**PAVEMENT DESIGN REPORT
STERLING RANCH EAST, FILING NO. 1, PHASE A, PART 2
EL PASO COUNTY, COLORADO**

PCD File No. SF22035

April 16, 2025

**SWELL/COLLAPSE TEST RESULTS**

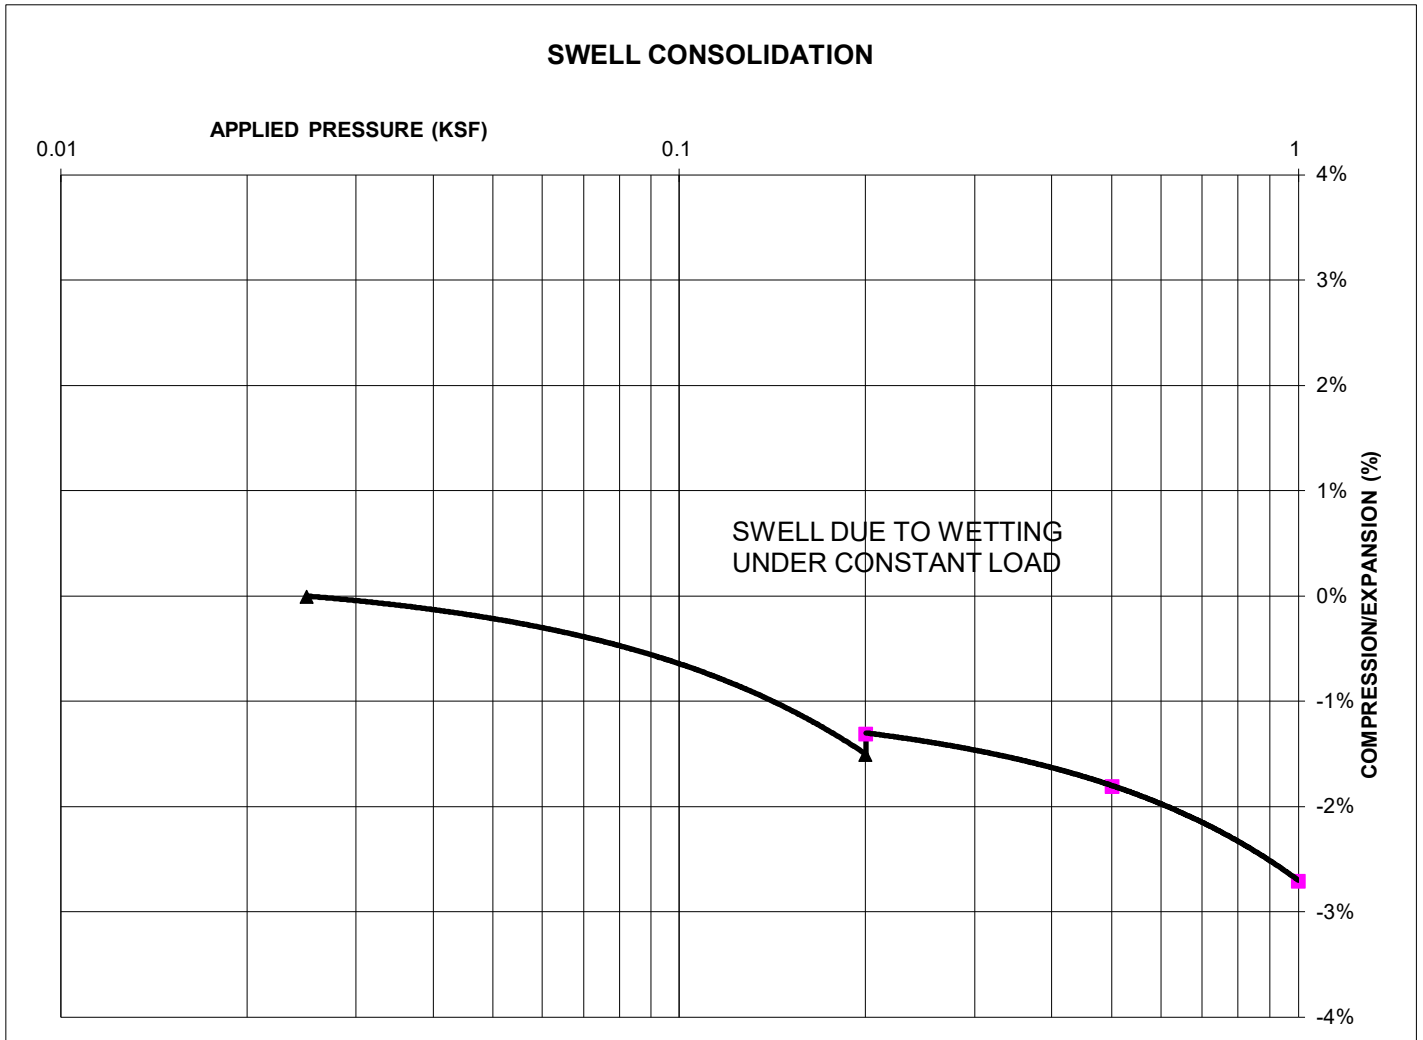
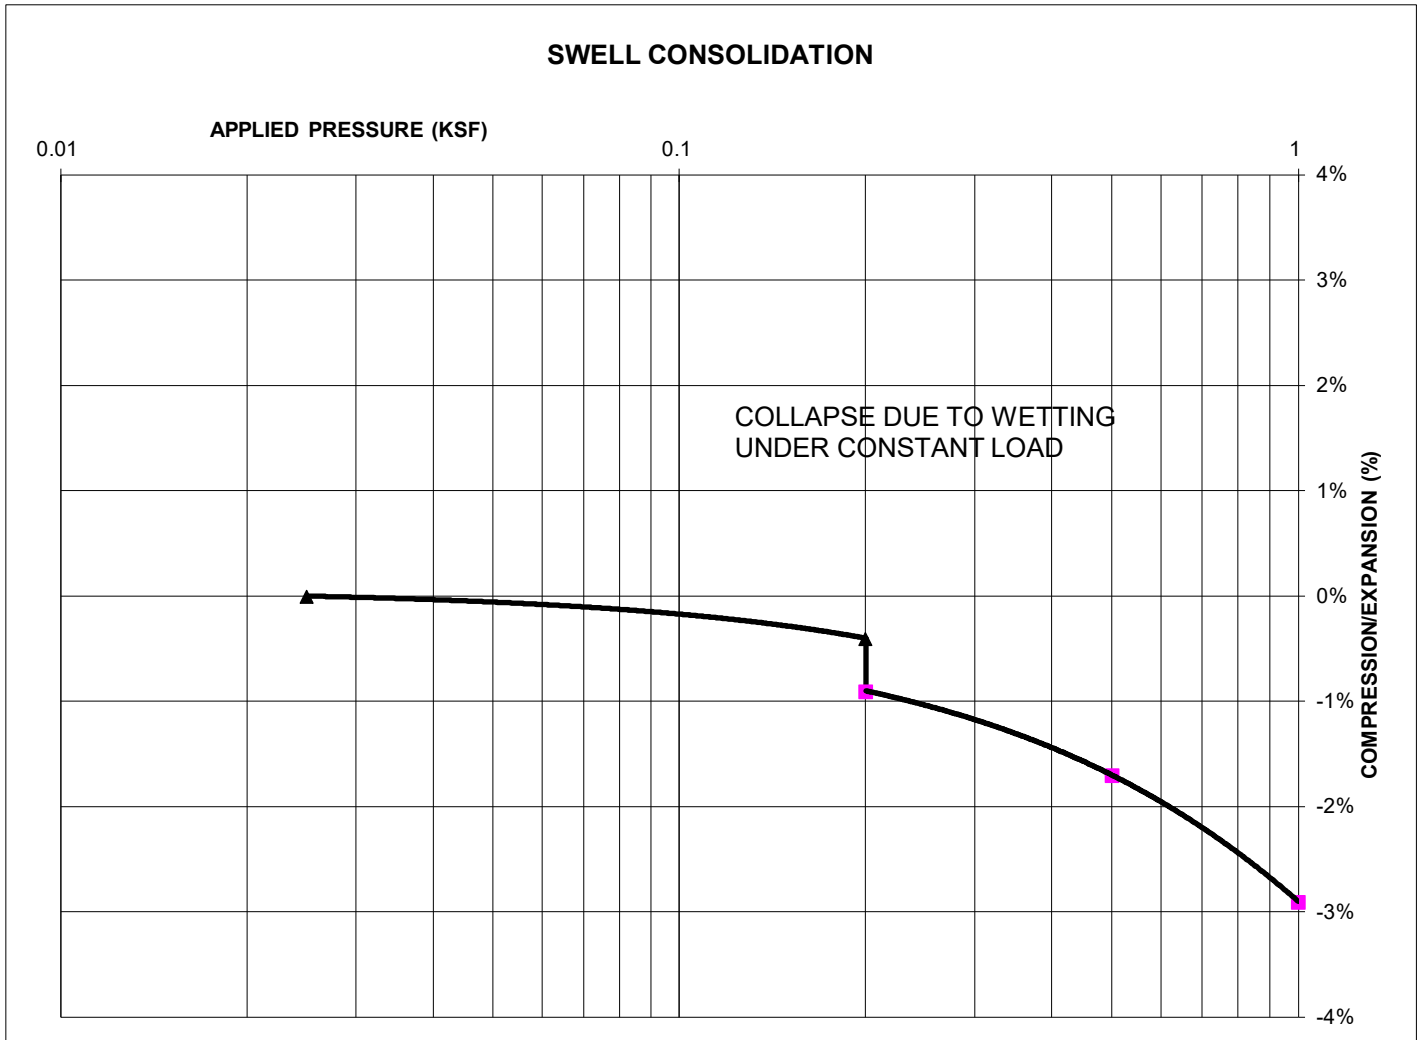
Please include swell
test results/graphs
